From: Darren Schofield [REDACTED]
Sent: 27 February 2018 10:39
To: Michael Eastham
Subject: RE: Courtwick Littlehampton - variation of conditions 4 & 24 - Ref LU/408/17/PL

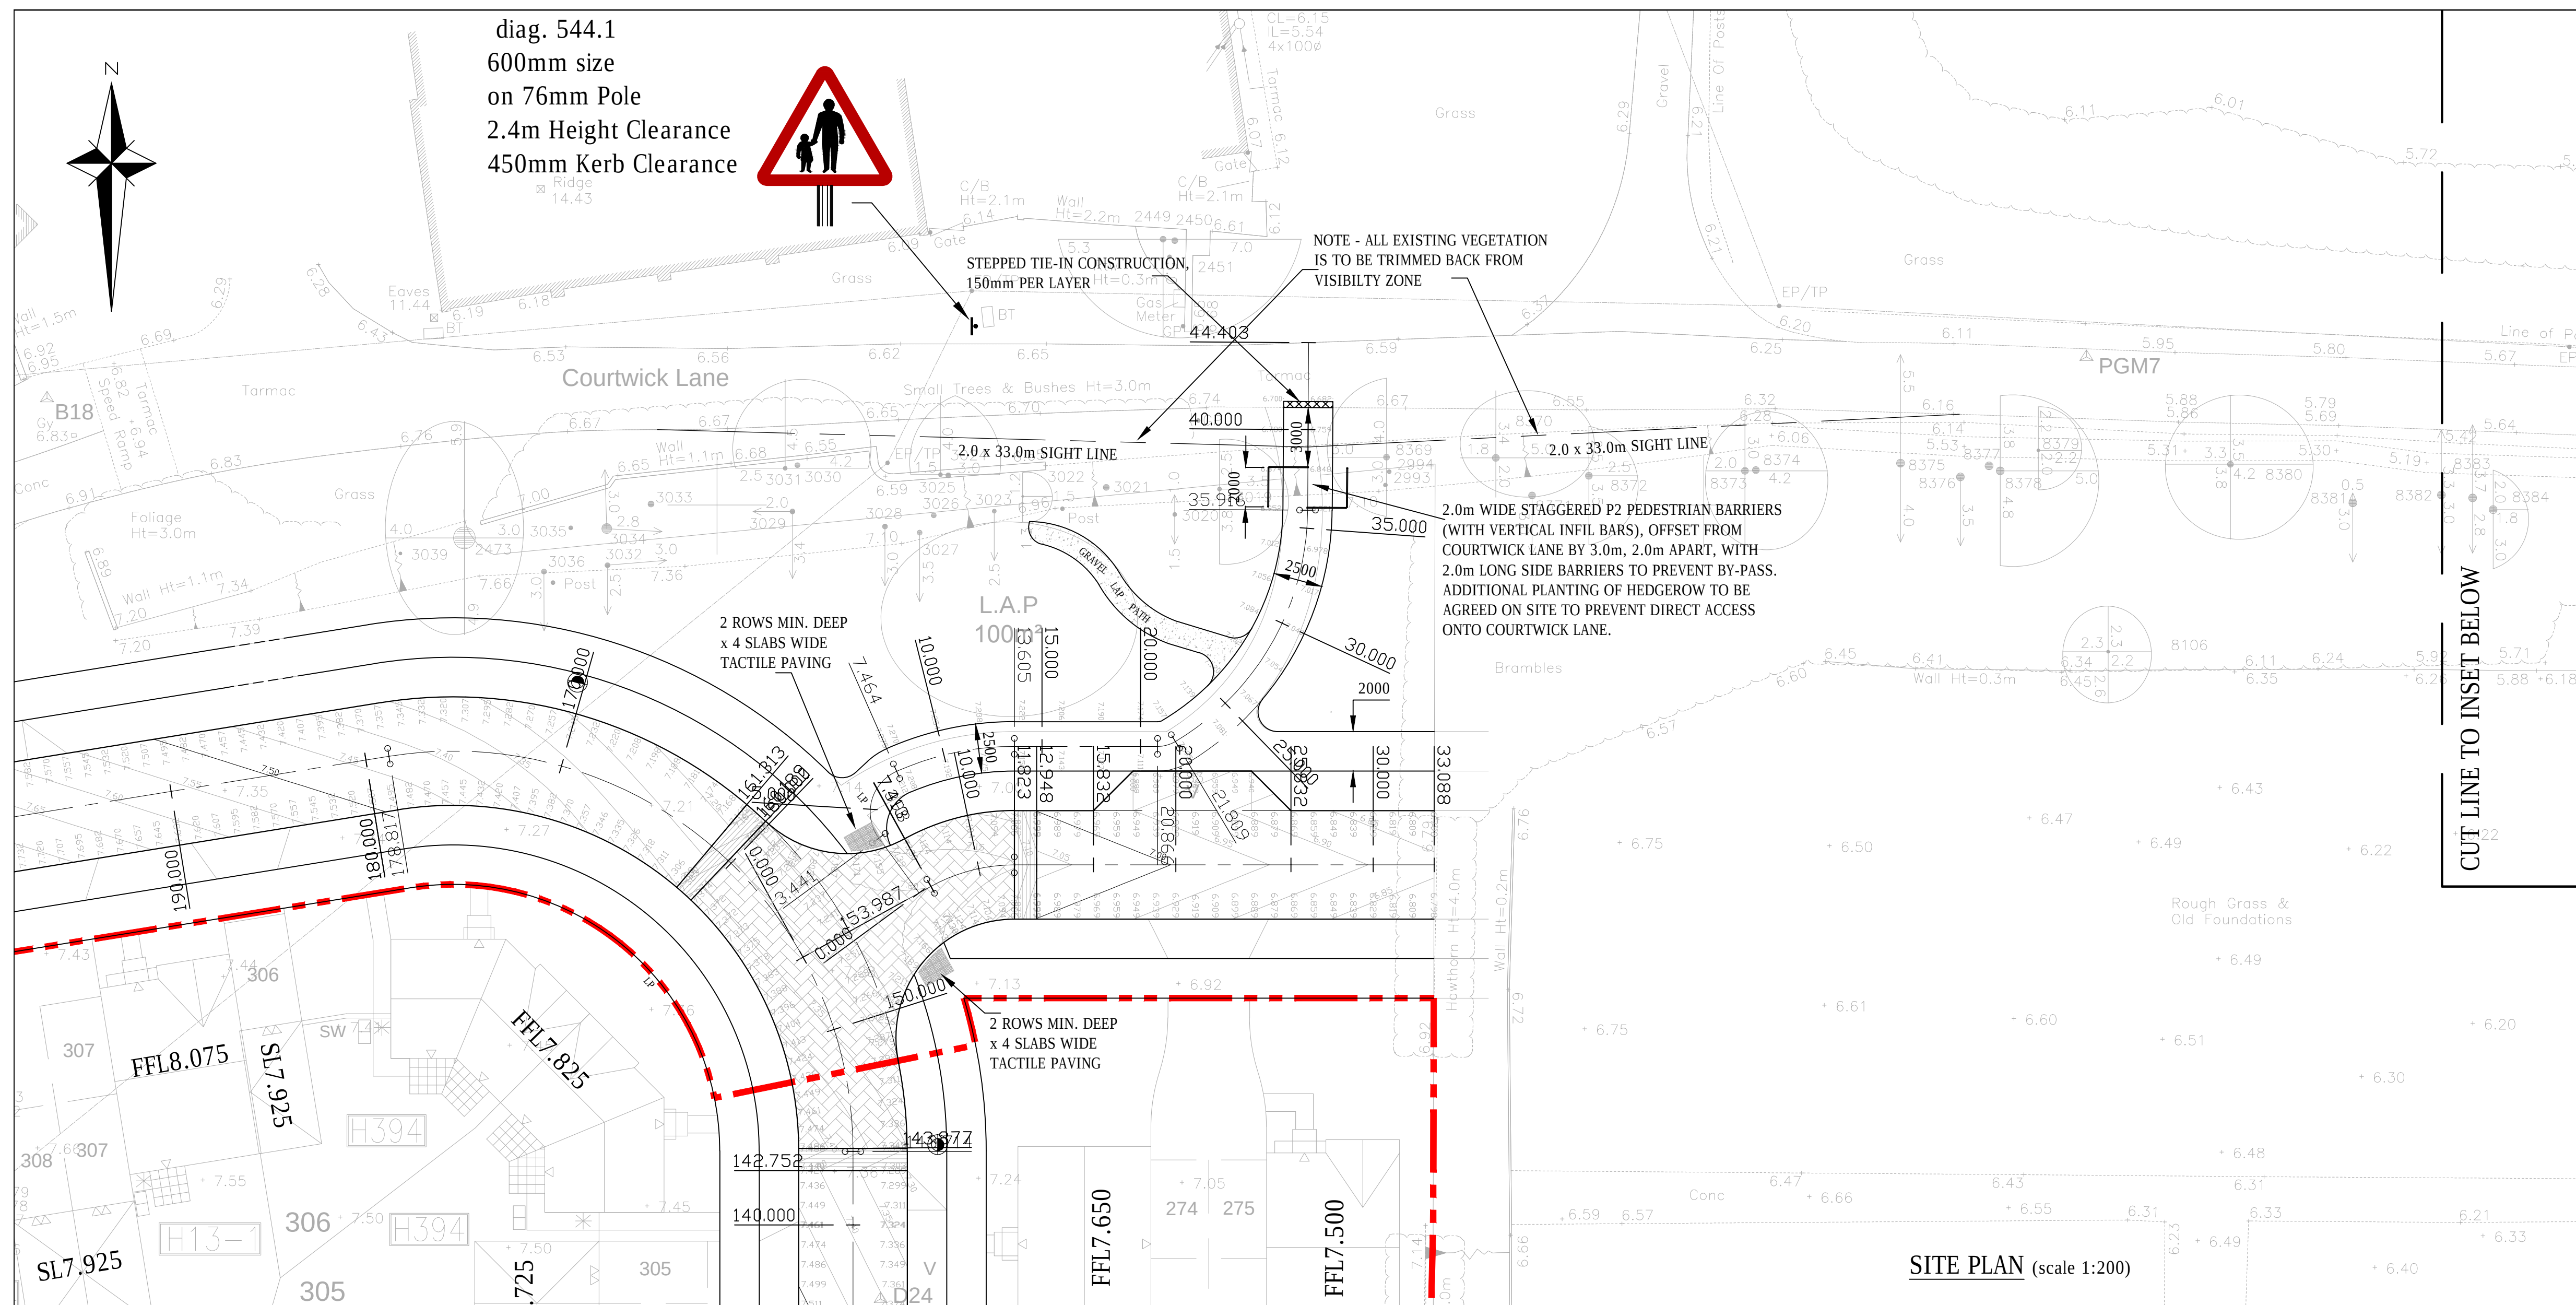
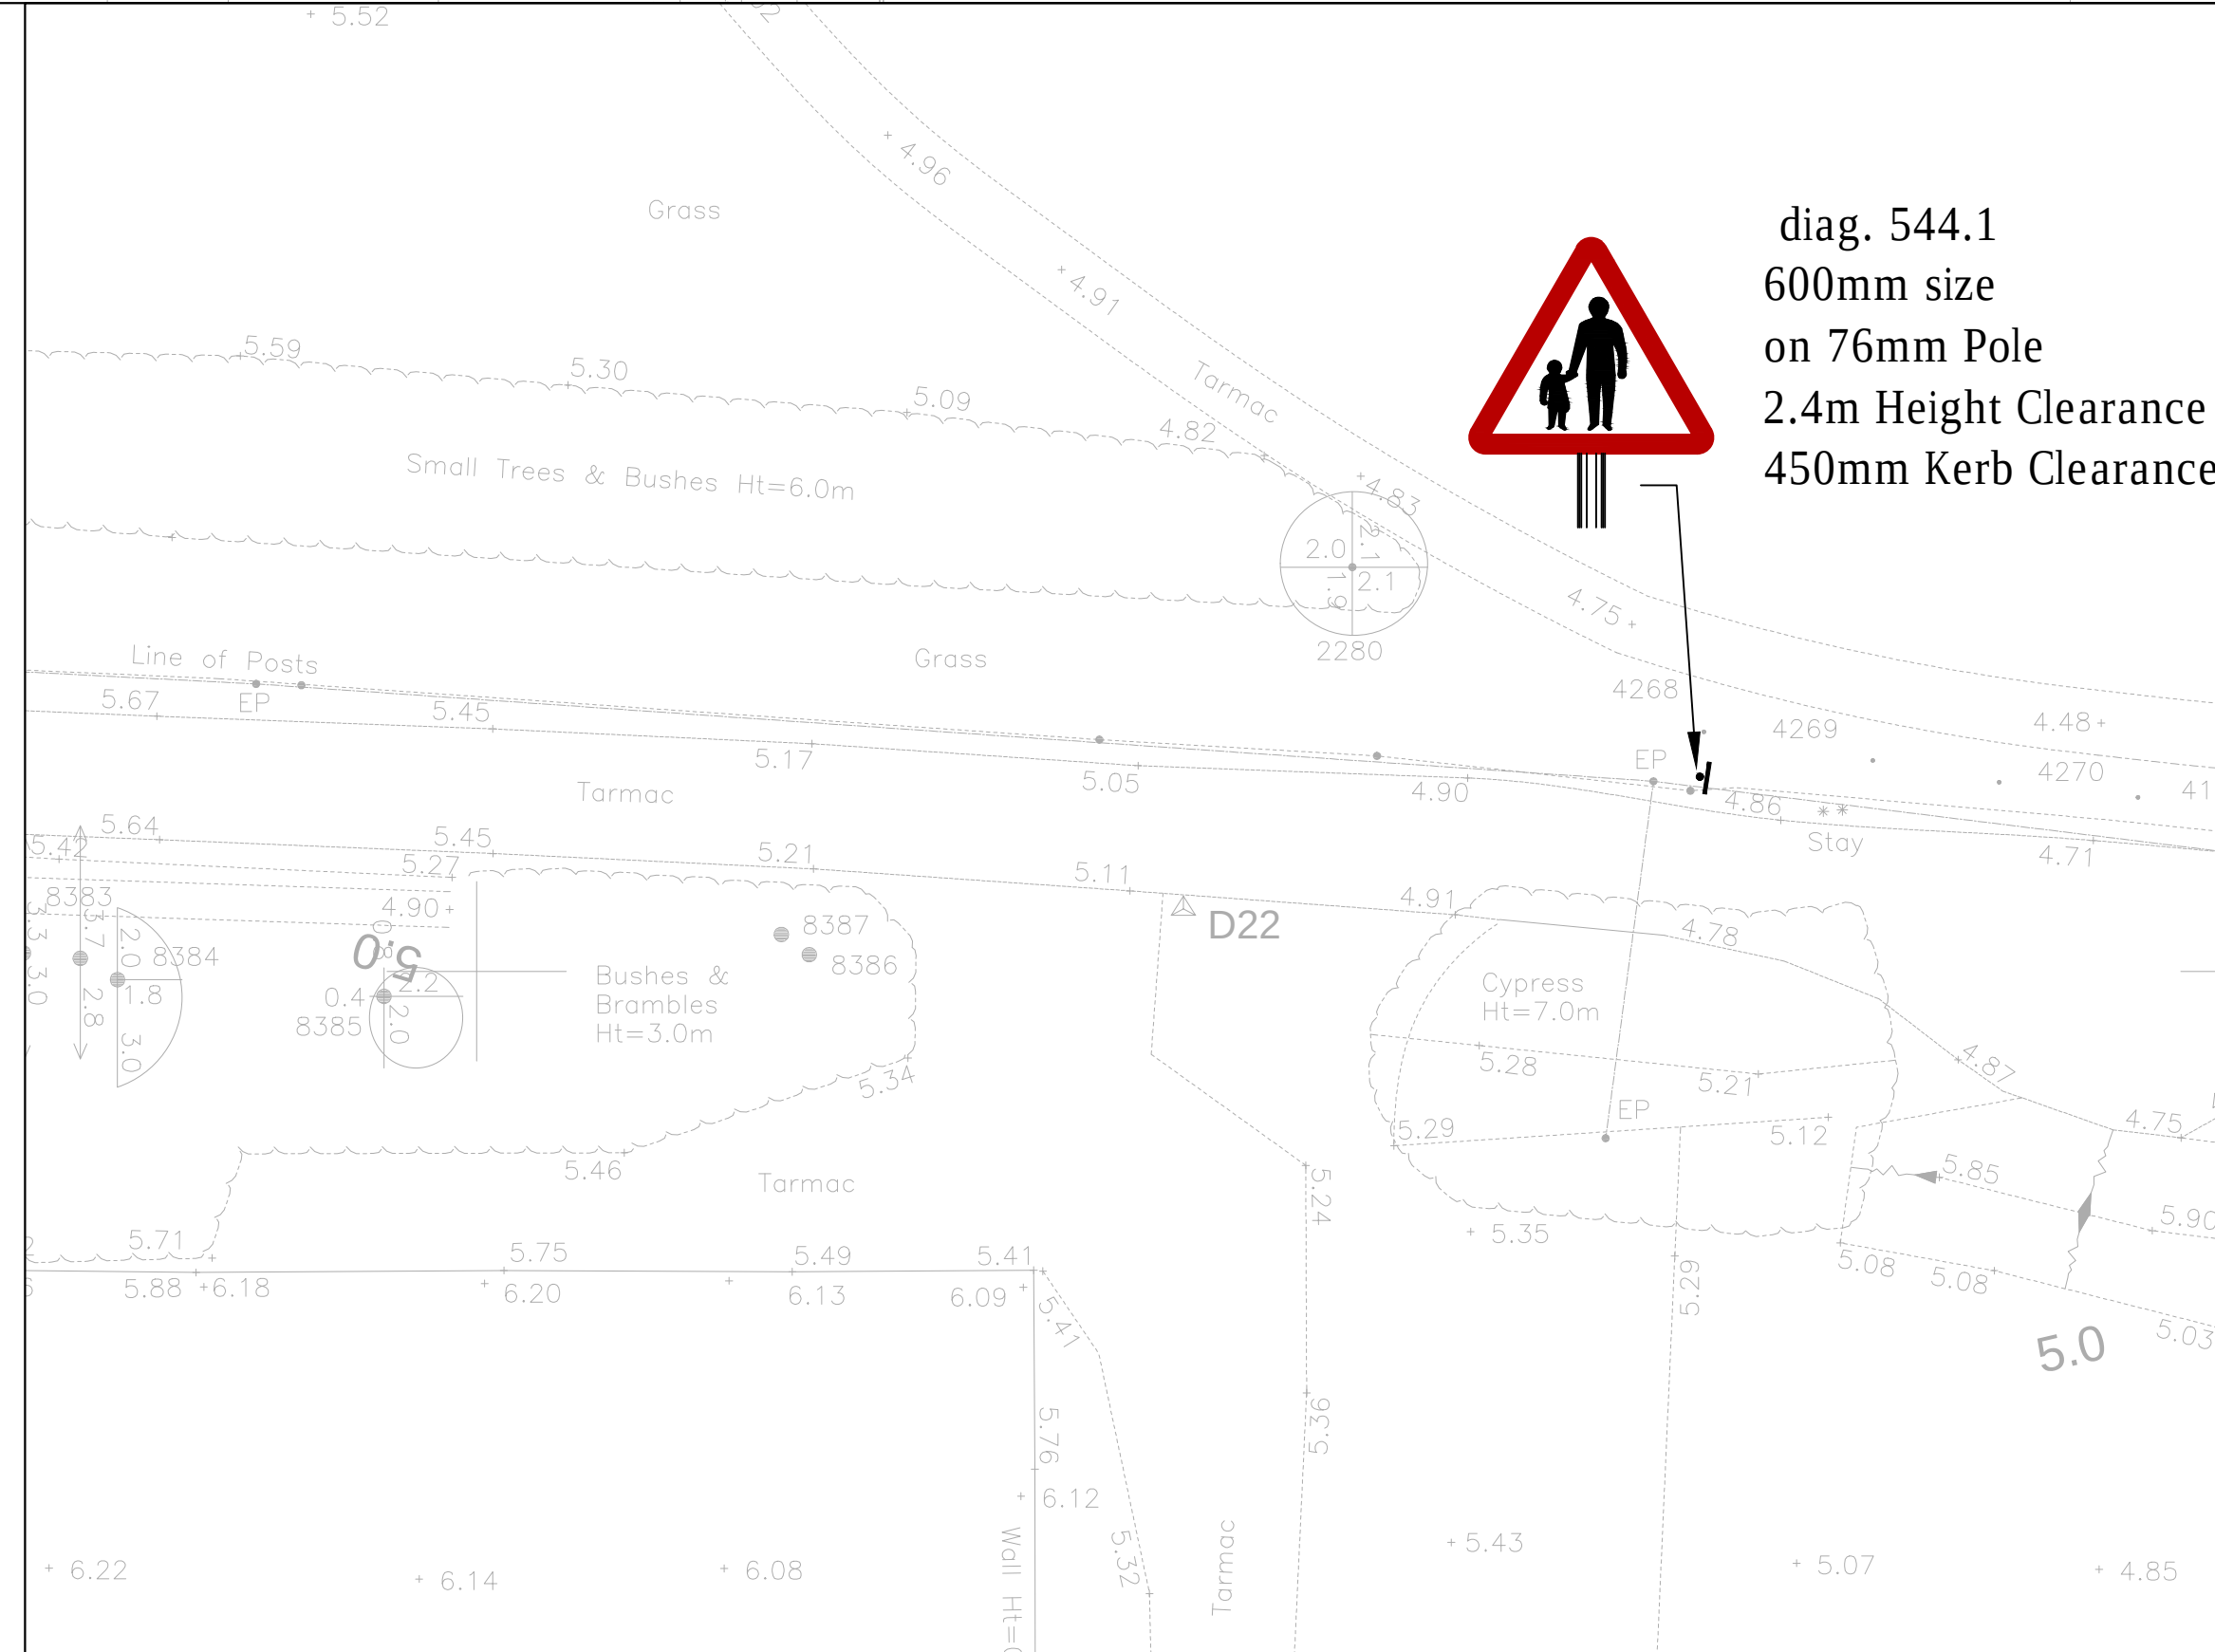
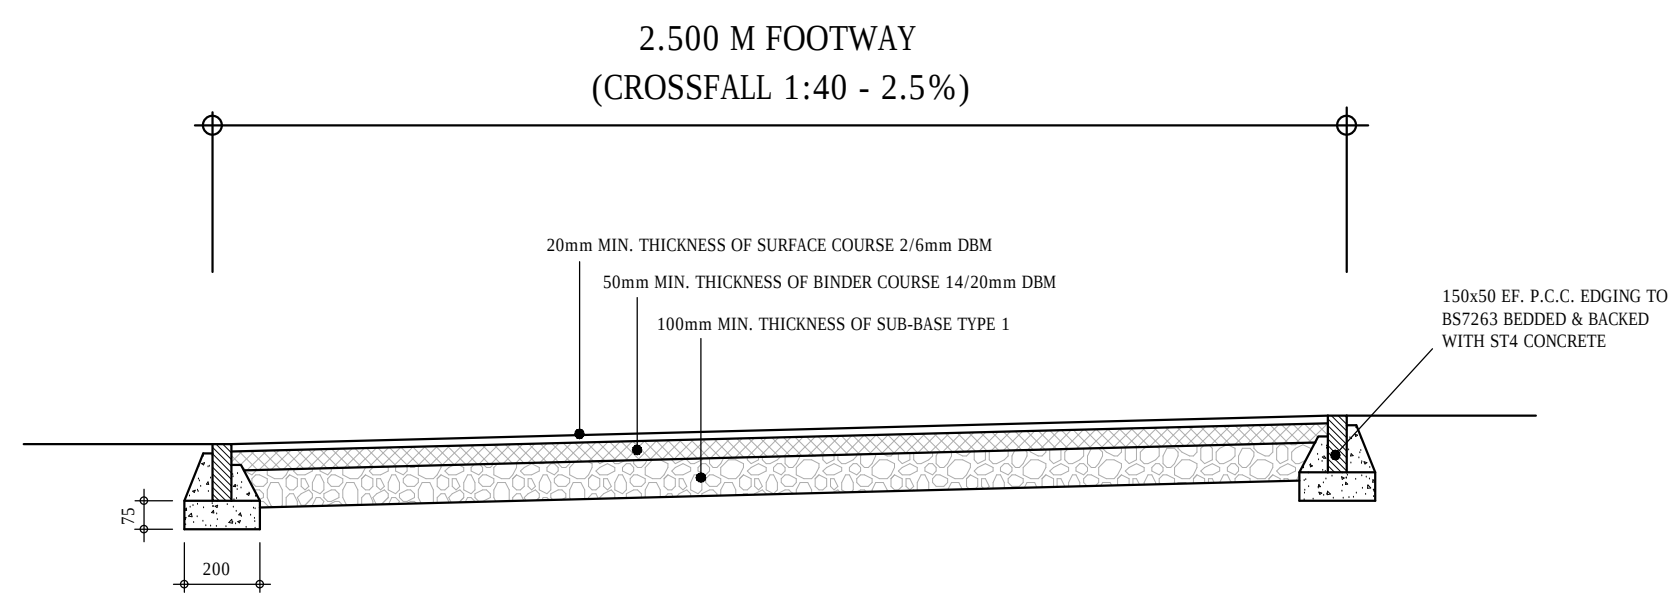
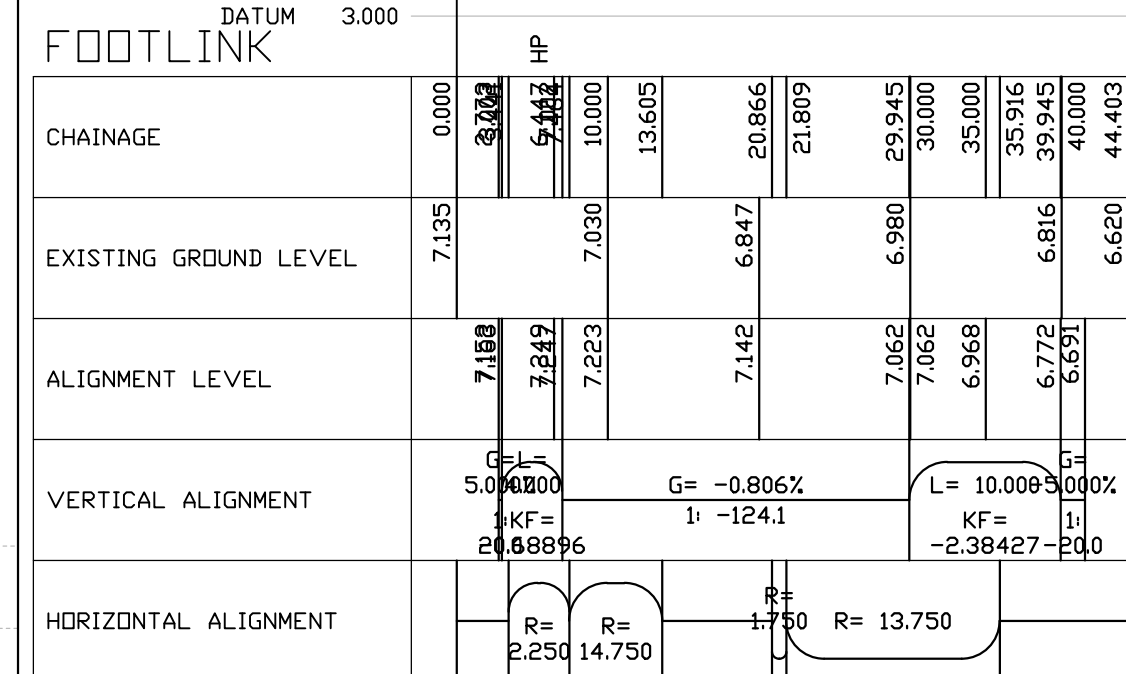
One further point that I meant to include on the email below. Please would you also ask Bellway to demonstrate on a plan that those with pushchairs and mobility scooters can negotiate the barriers. Also with the revised sight line, the barriers will need setting-back to accommodate the greater 'x' distance.
